# Immingham Green Energy Terminal

9.3 Applicant's Responses to the Examining Authority's First  
Written Questions

(Responses to "Q1.7. Landscape and Visual Effect")

Document Reference: TR030008/EXAM/9.3

FIGURE TITLE
 Viewpoint Locations

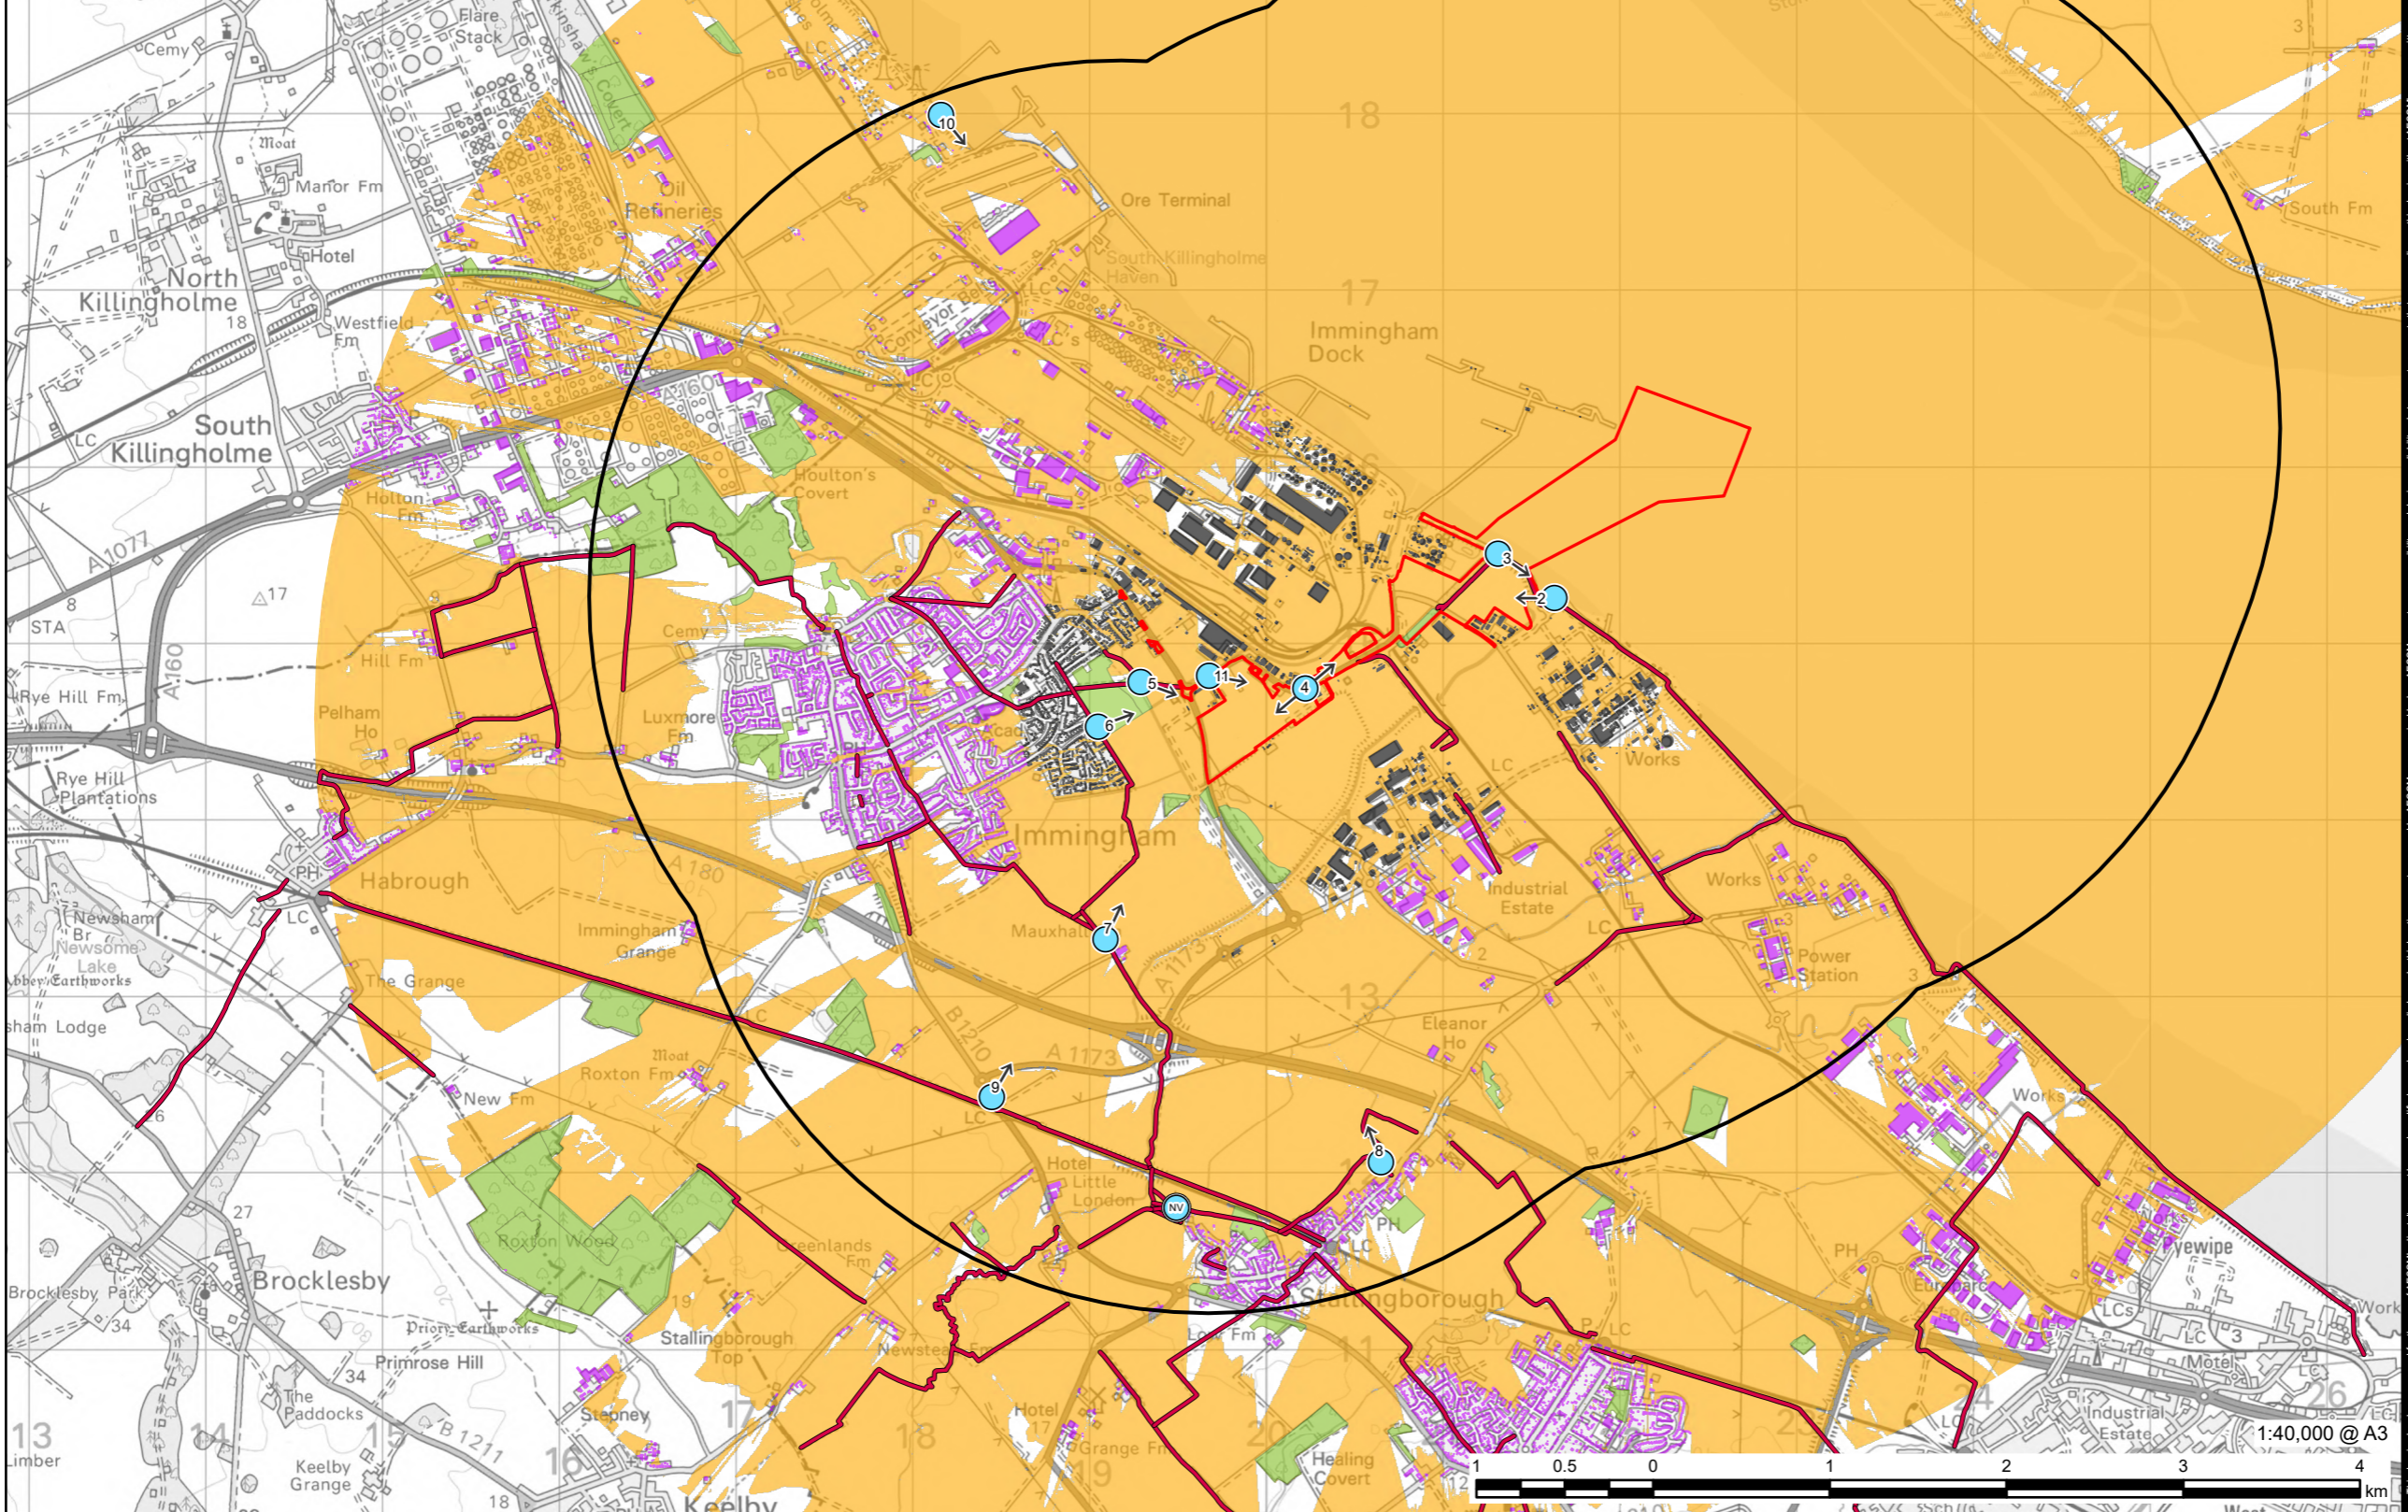
| Q1.7. Landscape and Visual Effect   |  |
|---|--|
| <p><b>Views Do Not Correlate</b></p> <p>The ES [APP-115, 13.8.6] shows Viewpoint 4 in summer. This is not taken from the same location as Viewpoint 4 in winter [APP-115, 13.9.6]. The winter viewpoint location is the one chosen for the photomontage [App-117] whereas it is considered that the summer viewpoint provided will more accurately show the extent of the Proposed Development in this area. Update the photomontage in relation to the summer viewpoint.</p> | <p>It is acknowledged that the winter viewpoint (<b>Environmental Statement ("ES") Figure 13.9.6: Viewpoint 4b Queens Road [APP-116]</b>) is located at E520165, N414737 and the summer viewpoint (<b>ES Figure 13.8.6: Viewpoint 4b Queens Road [APP-115]</b>) at E520221, N414734. These are located approximately 50m apart.</p> <p>The winter viewpoint was selected for the photomontage (refer to <b>ES Figure 13.10.4 [APP-117]</b>) as this shows the Project in context with the residential properties on Queens Road.</p> |

| <p><b>Additional photomontages</b></p> <p>The ES concludes [APP-055, Paragraph 13.8.16] that Viewpoints 2, 3 and 11 are likely to result in a significant landscape and visual impact. Photomontages have been provided for Viewpoints 2, 4 and 6.</p> <p>a) Applicant – In order to consider the potentially most significant residual effects, provide photomontages for Viewpoints 3 and 11.</p> <p>b) NELC – Indicate whether there are any additional views that you consider require photomontages.</p> | <p>It is acknowledged that photomontages have not been produced for Viewpoint 3 and Viewpoint 11, which have both been assessed as likely to experience significant visual effects.</p> <p>Photomontages were not produced for Viewpoint 11 as, whilst significant effects are assessed as likely during the construction phase for residential receptors located on Queens Road, Viewpoint 11 was not assessed in the operational phase as the ten residential properties are proposed to be acquired to facilitate the Project as outlined in <b>Paragraph 13.8.14 of Environmental Statement Chapter 13: Landscape and Visual Impact [APP-055]</b>. Additional photography was taken in February 2024 and using this photography an additional photomontage will prepared to represent views and extent of the Project in the context of Kings Road and submitted at Deadline 3 (3 May 2024). The location and orientation of the viewpoint has been amended slightly to better represent the extent of the Project as the original orientation was directed at a small building at the edge of the site which obscured the wider context.</p> <p>Viewpoint 3 was assessed as likely to result in significant effects during the construction and operation of the Project; however, the direction of view taken from the viewpoint photography represents views to the south, towards the proposed Temporary Construction Area off Laporte Road</p> |

|   | <p>Additional winter photographs were taken in February 2024 at the summer viewpoint location and an additional photomontage will be provided at Deadline 3 (3 May 2024) to show the extent of the Project from Queens Road.</p>  |

|   | <p>(Work No. 9). Updated photographs were taken in February 2024 for Viewpoint 3 to represent views to the south-west, towards the Project, from the Public Right of Way (Bridleway 36). A photomontage will be submitted at Deadline 3 (3 May 2024) to show the extent of the Project using the updated photography.</p>  |
